Road Safety Audit Designers Response Report

Report Title	Road Safety Audit Designers Response
Date	17/10/2022
Document Reference and Revision:	R01-FC-RSA Designers Response
Prepared by:	Francois Chate
On behalf of:	Bicester Gateway Ltd
AUTHORISATION SHEET	
Project:	Bicester Gateway RM
Report Title	Road Safety Audit Designers Response
PREPARED BY	
Name:	Francois Chate
Signed:	<i>François Chaté</i>
Organisation:	Vectos South Ltd
Date:	19/10/2022

GENERAL DETAILS:			
Highway scheme name and road number:	Bicester Gateway Phase 1b – Access Proposals		
Date:	October 2022		
Type of scheme:	Employment development – on open land – 11,745sqm GIA		
RSA Stage:	<input checked="" type="checkbox"/> Stage 1	<input type="checkbox"/> Stage 2	<input type="checkbox"/> Stage 3
	Interim		<input type="checkbox"/> Stage 4
Road Safety Audit Reference:	: L:\Projects\220000\226701 - Bicester Gateway RMA\Technical\C - RSA\226701-Bicester Gateway-RSAS1 - 141022.docx		
Designers Response prepared by:	Francois Chate		
Design organisation details:	Vectos South Ltd

DRAWING NUMBER: **226701_PD02** REVISION: .

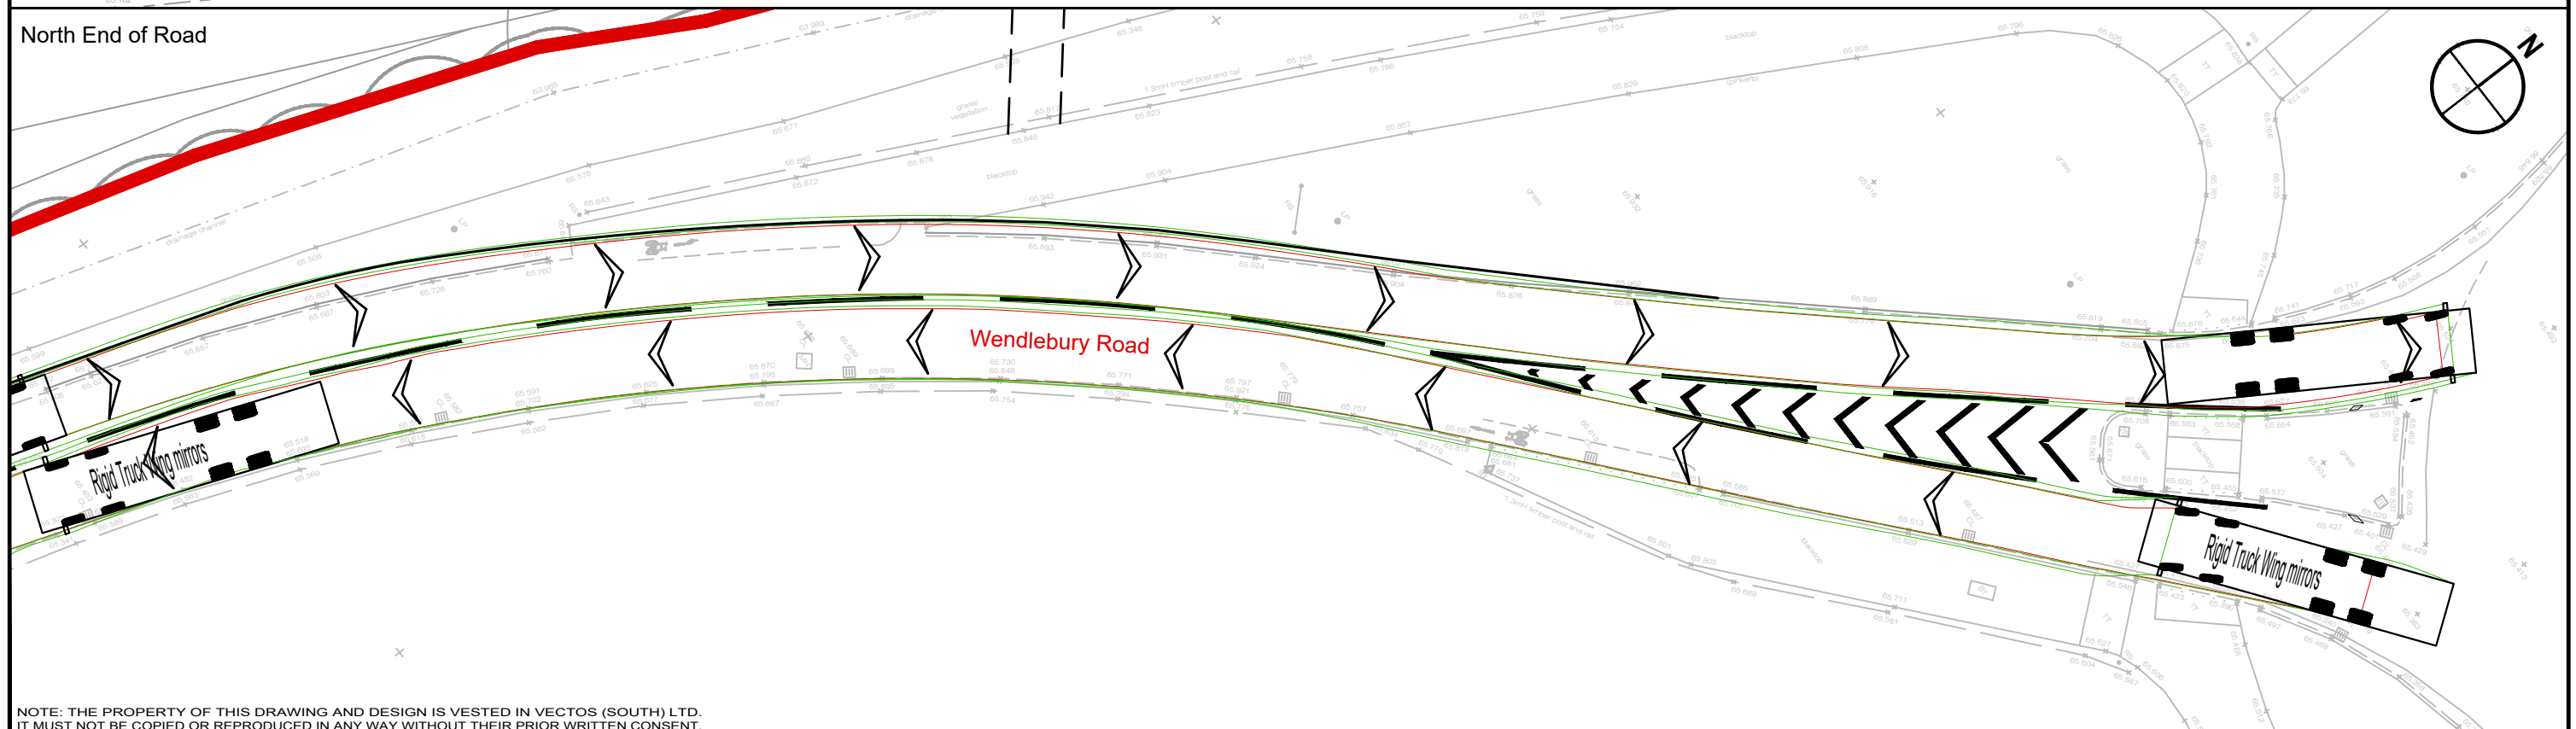
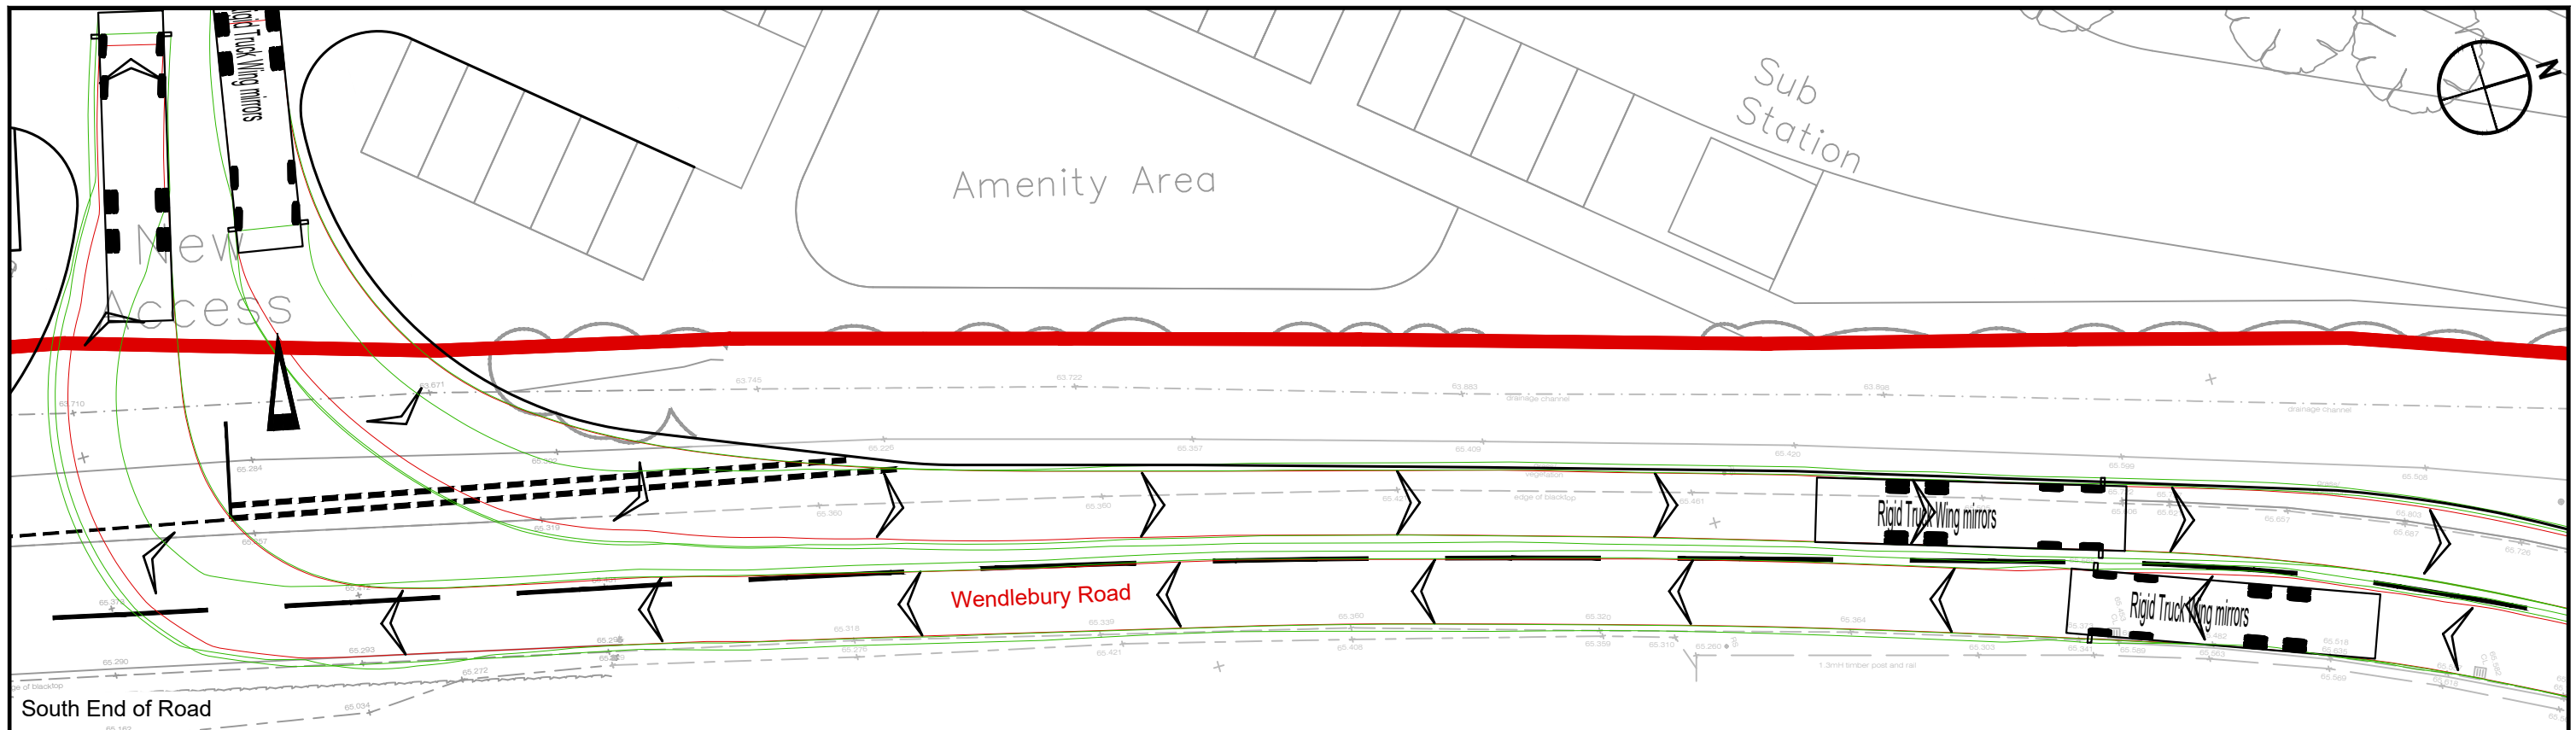
2.3	It is recommended that the appropriate visibility splay in line with vehicle	Rejected – Drawing 226701_PD02 rev A shows that visibility can be delivered at

speeds is achieved and maintained free from obstruction.	the proposed access within highway land. The highway boundary as per information provided by Oxfordshire County Council is now shown on the plan. Visibility splays of 2.4m x 120m, suitable for a 40mph, and of 2.4m x 90m, suitable for a 30mph, can both be delivered within highway land.		
--	--	---	--	--
